## APPLICANT'S RESPONSES TO THE EXAMINING AUTHORITY'S SECOND WRITTEN QUESTIONS (EXQ2)

HyNet Carbon Dioxide Pipeline DCO

**Document Reference Number D.7.48**

DATE: July 2023

DRAWING NUMBER
EN070007-APP-ES-17.4-Sheet 3

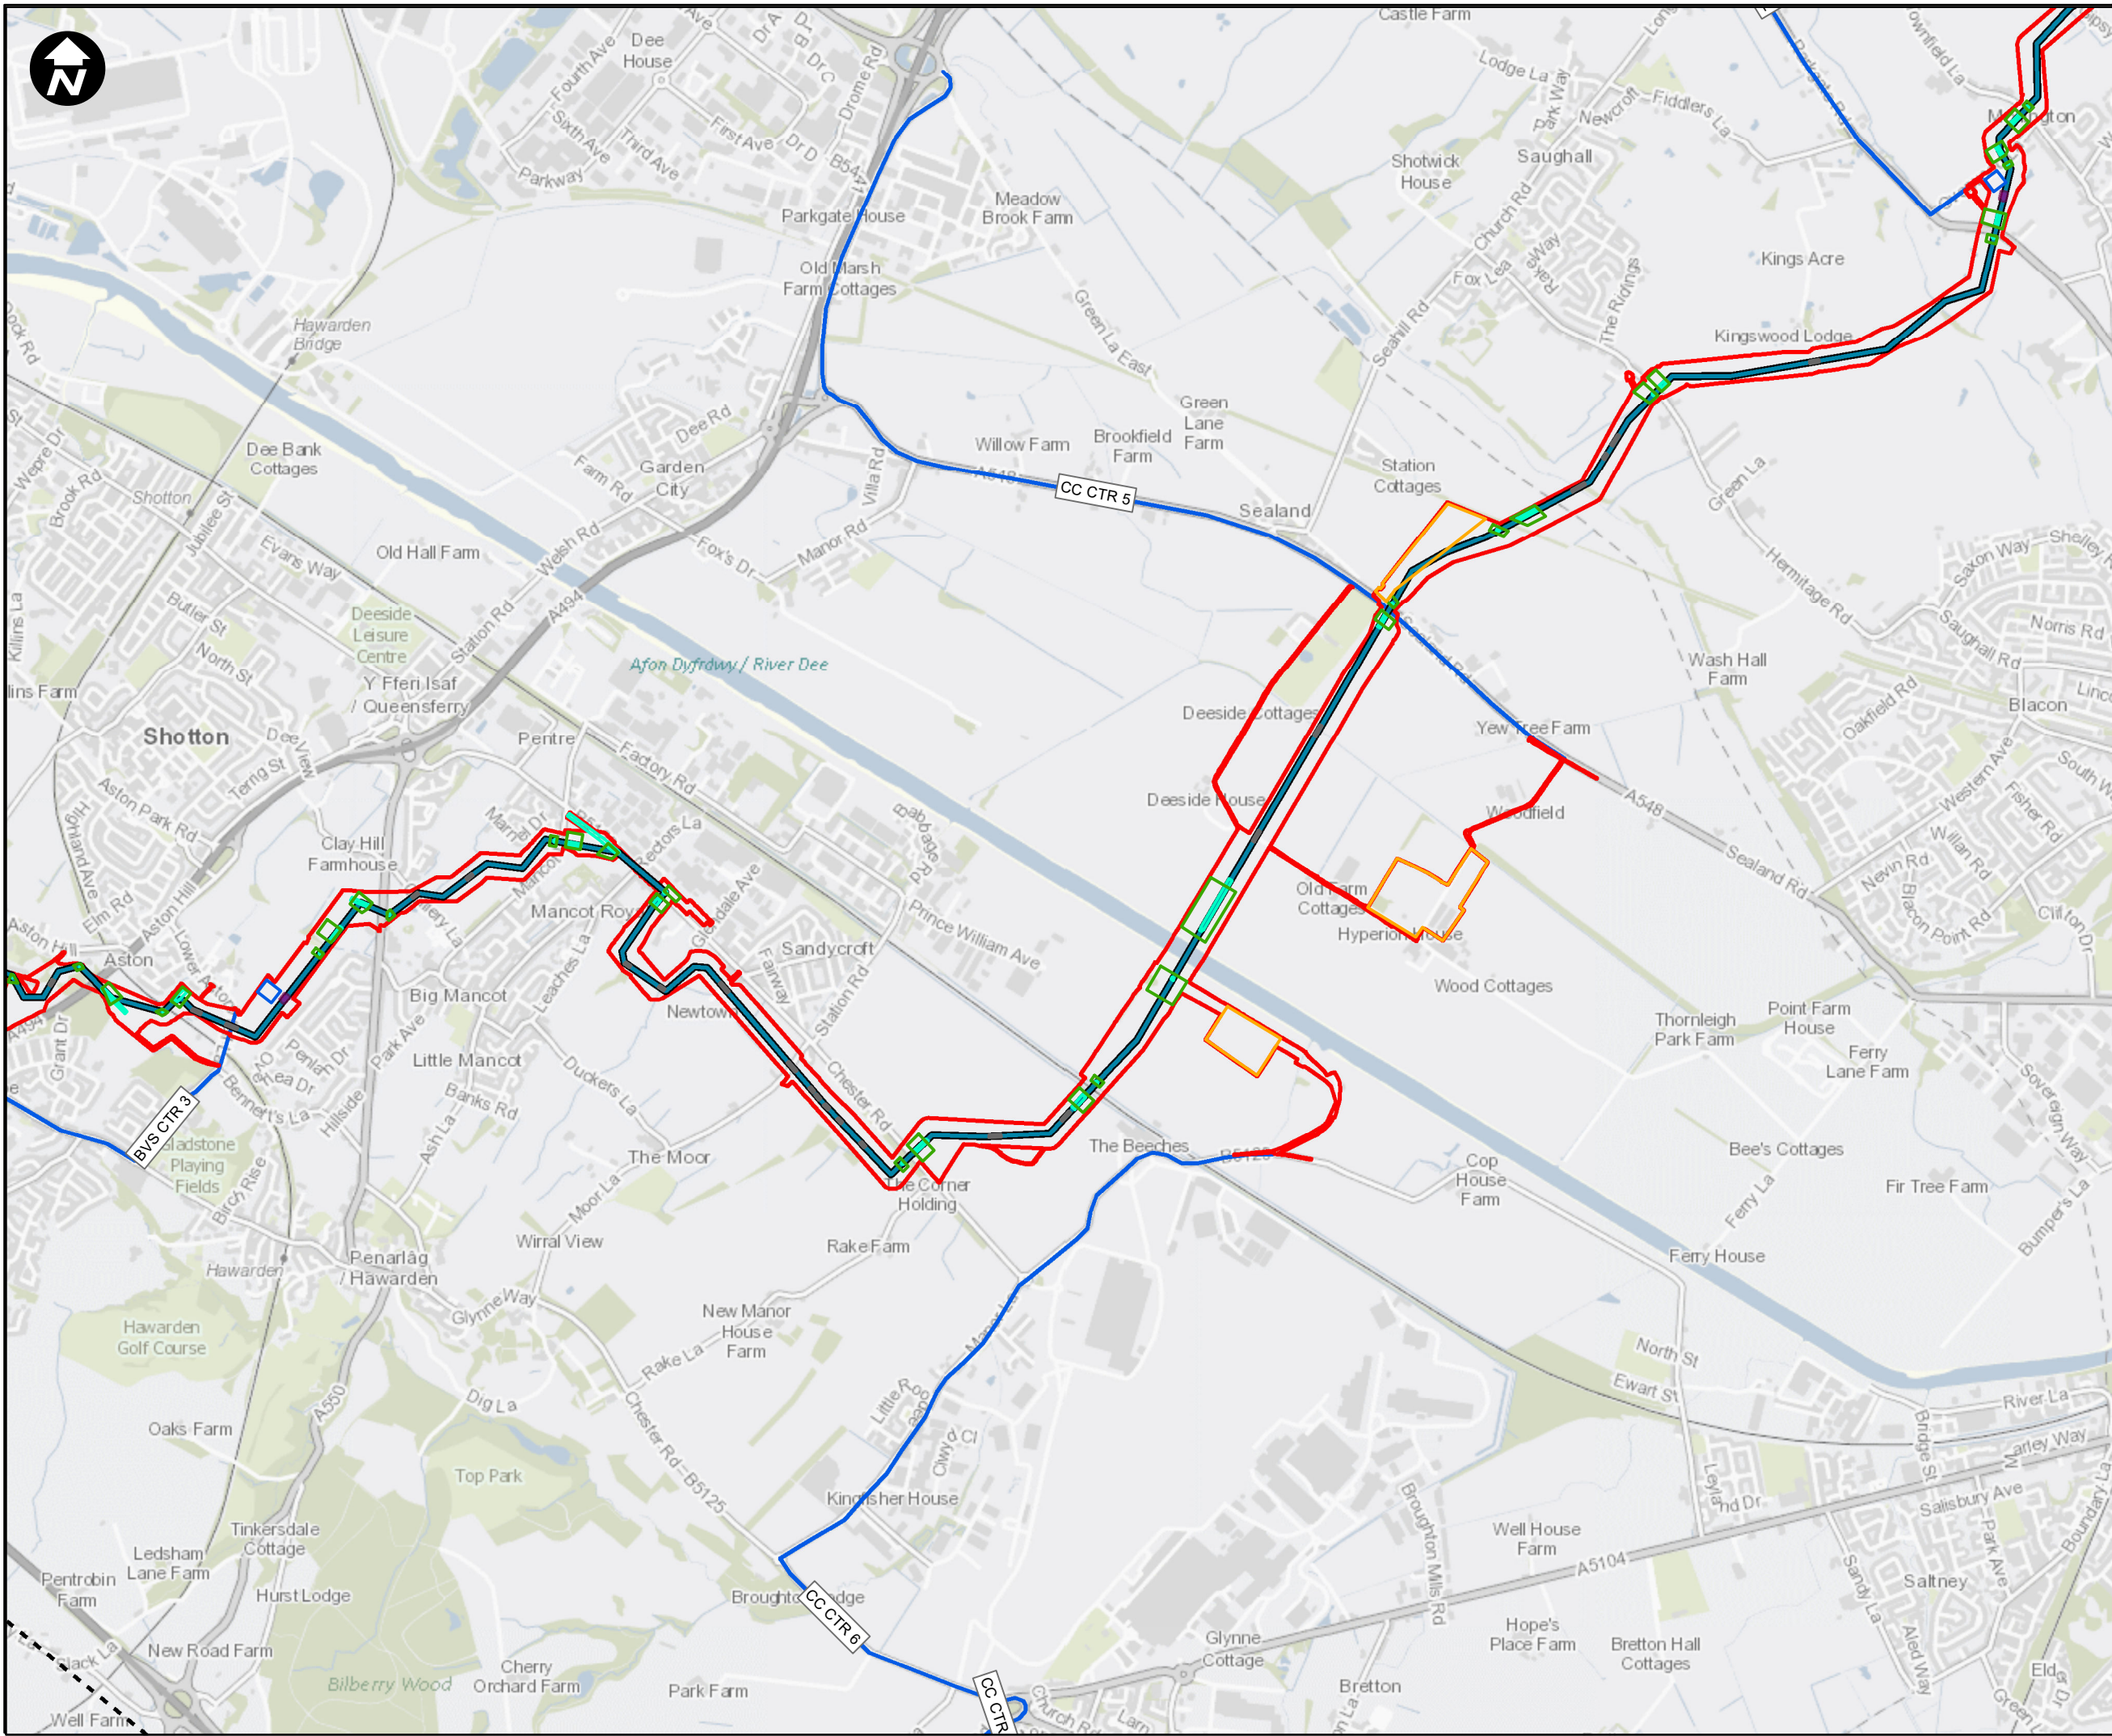
Q2.1.3	<i>Clarification</i> Applicant	Figure 17.4 (Construction Access) [CR1-092] is unclear in regard to AG1 CTR1, which appears to be obscured by the red line Order boundary. Please review and amend, if required.	<p>AG1 CTR1 runs along Pool Lane to the junction with Grinsome Road and along Ash Road to the rail bridge at the entrance to Encirc. The construction traffic route is then off public highway within the Order Limits. The blue line denoting AG1 CTR1 in Figure 17.4 (Construction Access) <b>[REP4-227]</b> is erroneously shown along Grinsome Road. This will be amended prior to the end of Examination.</p> <p>AG1 CTR1 is also erroneously labelled in Figure 17.4 (Construction Access) <b>[REP4-227]</b>, the label should read 'AGI CTR1'. This will be amended prior to the end of the Examination.</p>
Q2.1.4	<i>Clarification</i>	Peel NRE references "Future Planned Infrastructure" in its submissions. Can it elaborate on what this means? (e.g. Is it referring to an existing allocation in the	The Applicant would refer the ExA to the current position captured in the following Statements of Common Ground (SoCG's):
